From: Jeff Bender <jeffdbender@gmail.com>
Sent: Monday, August 22, 2016 2:29 PM
To: Scott Greenberg
Cc: Ali Spietz; Kari Sand
Subject: SEPA Determination for Proposed MICA Project - Comment Letter

Thank you for the opportunity to comment on the request for a State Environmental Policy Act (SEPA) environmental determination for the proposed Mercer Island Center for the Arts.

I have reviewed the MICA SEPA documents you sent me on August 10, specifically Attachment G: the MICA parking management plan (PMP) and the transportation impact analysis (TIA). Based on my review and information in documents pertaining to the City of Mercer Island's Comprehensive Plan update and Sound Transit's East Link Final Environmental Impact Statement (EIS), it is clear that the City's, i.e. Transpo Group's, initial evaluation of the proposed MICA project for probable significant adverse environmental impacts is deeply flawed. I recommend that the City require an environmental impact statement be completed for the project to achieve a complete and accurate environmental assessment with more opportunity for public review and comment.

## On-Street Parking Utilization Study

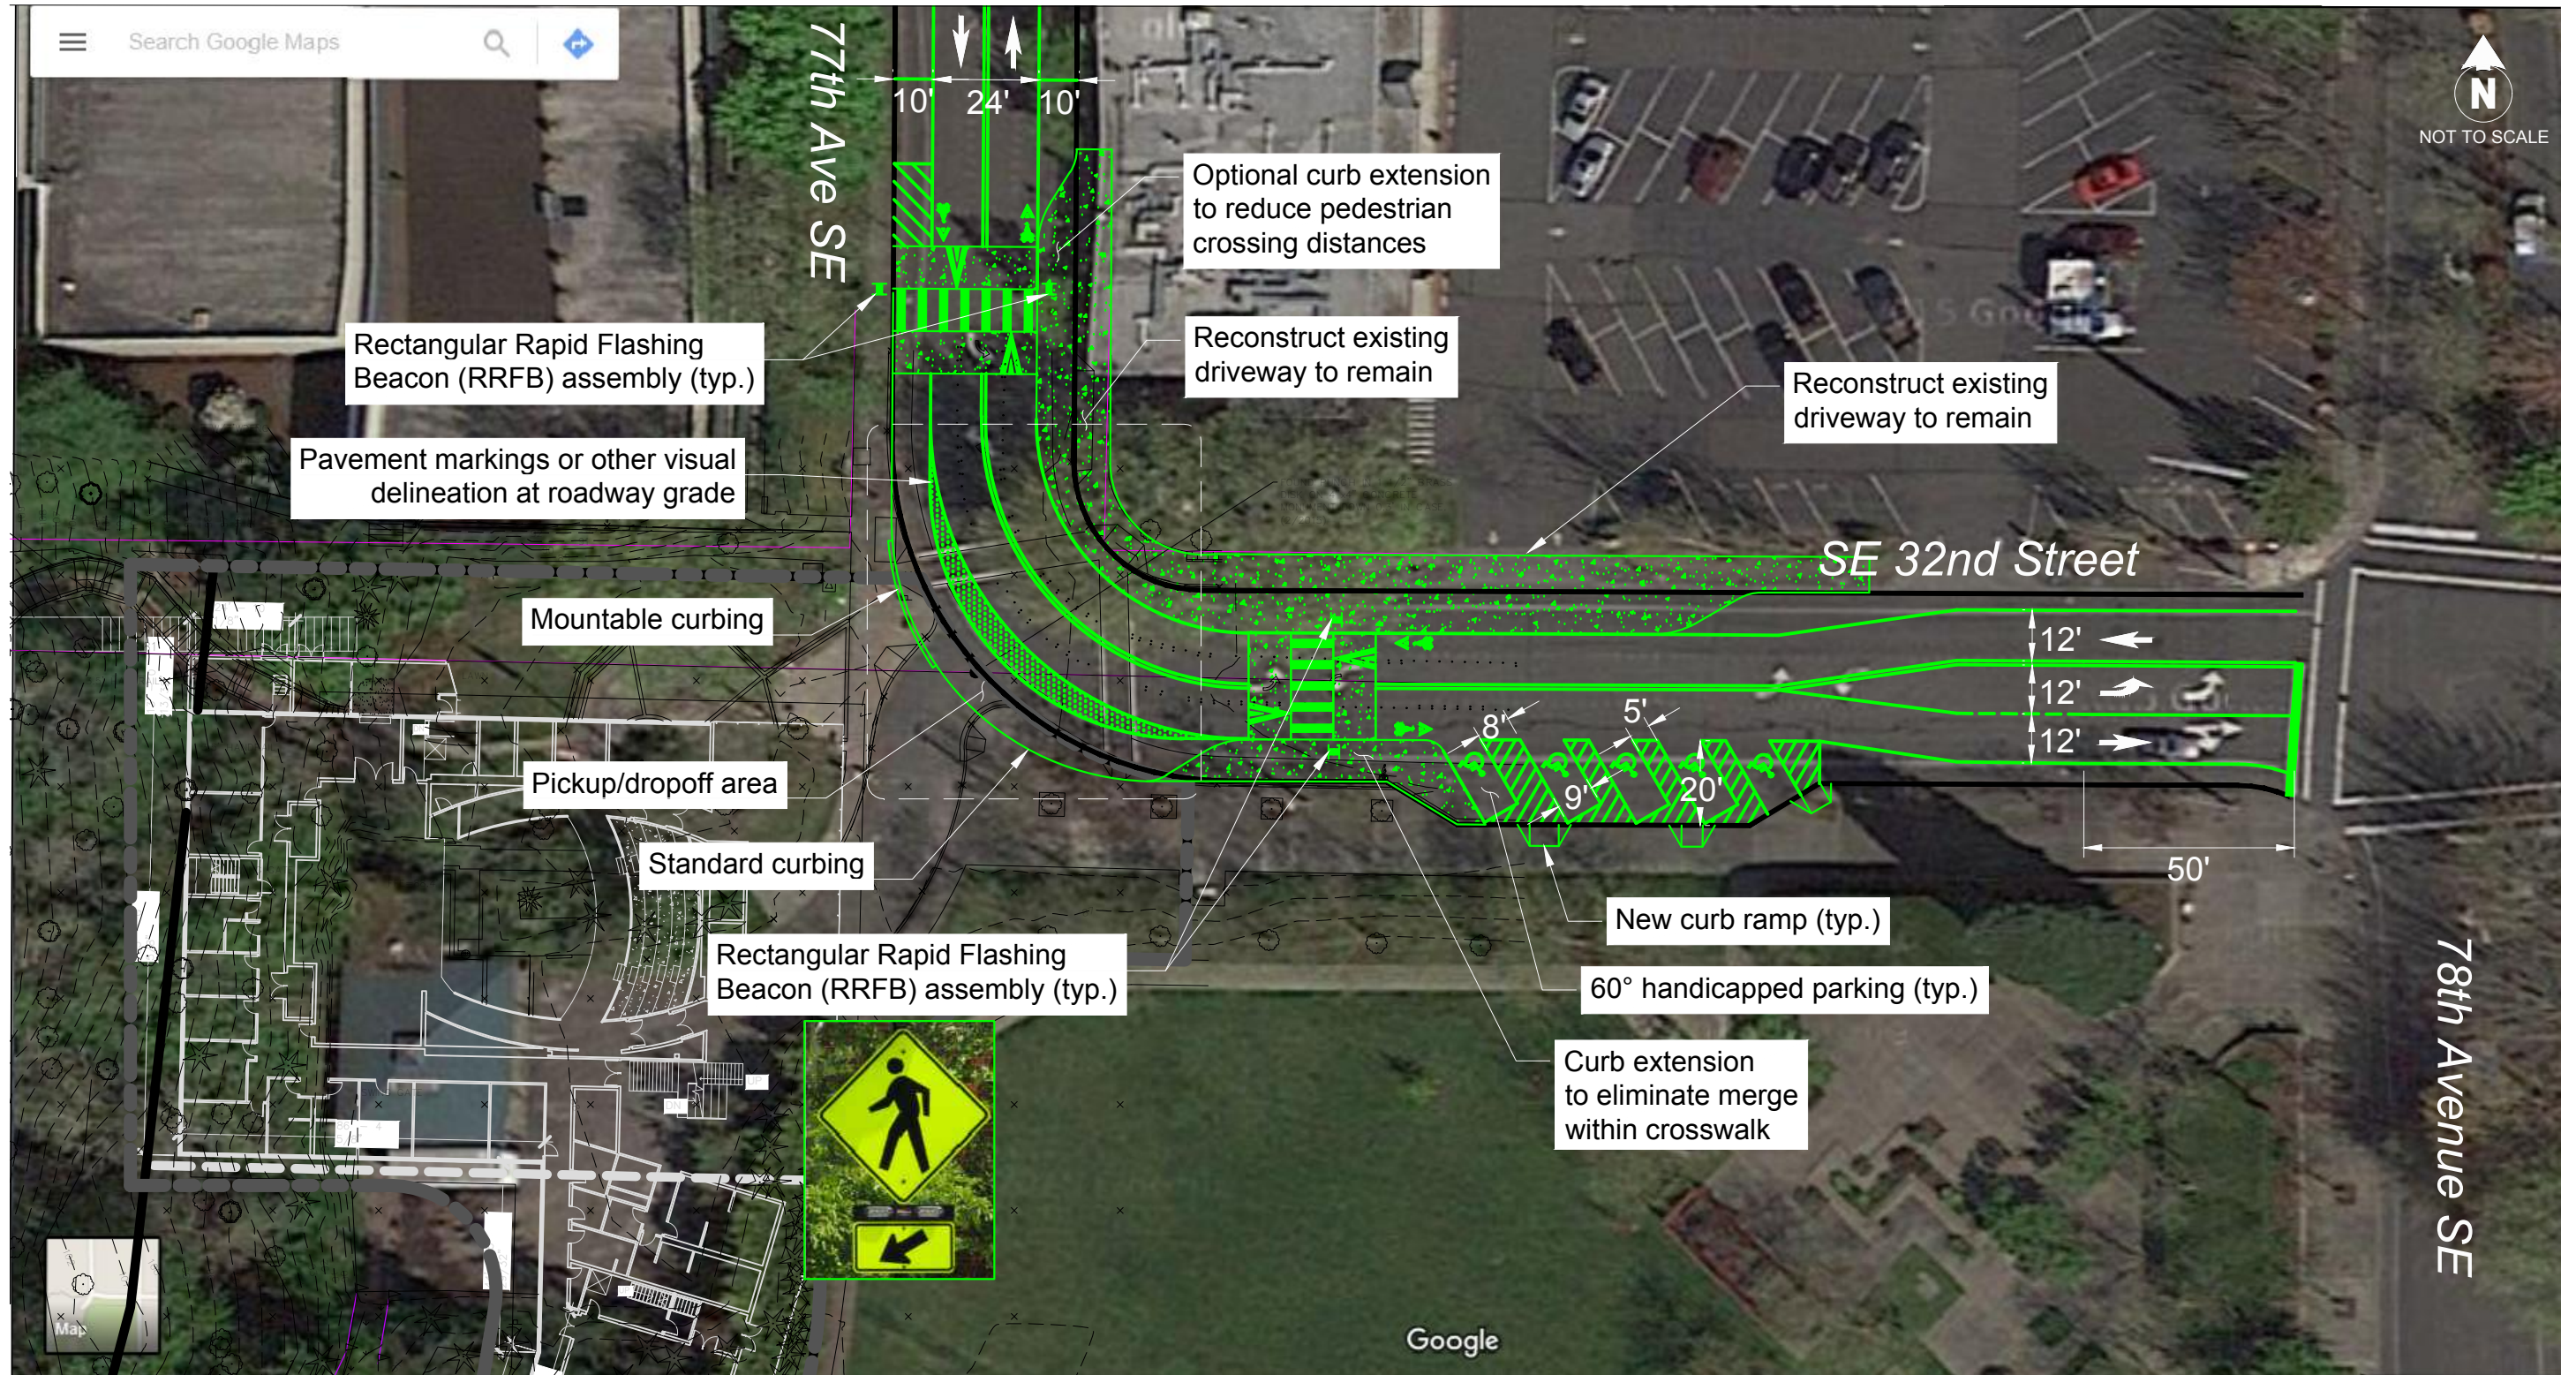
Finally, I would like to comment on the PMP. First, I would like to know what two days the on-street parking study was done. MIHS was on spring break the week of April 11-15. I would also like to note that the New Seasons grocery store is opening this fall near streets surveyed for on-street parking. This development will immediately impact the on-street parking supply that MICA is planning to use.
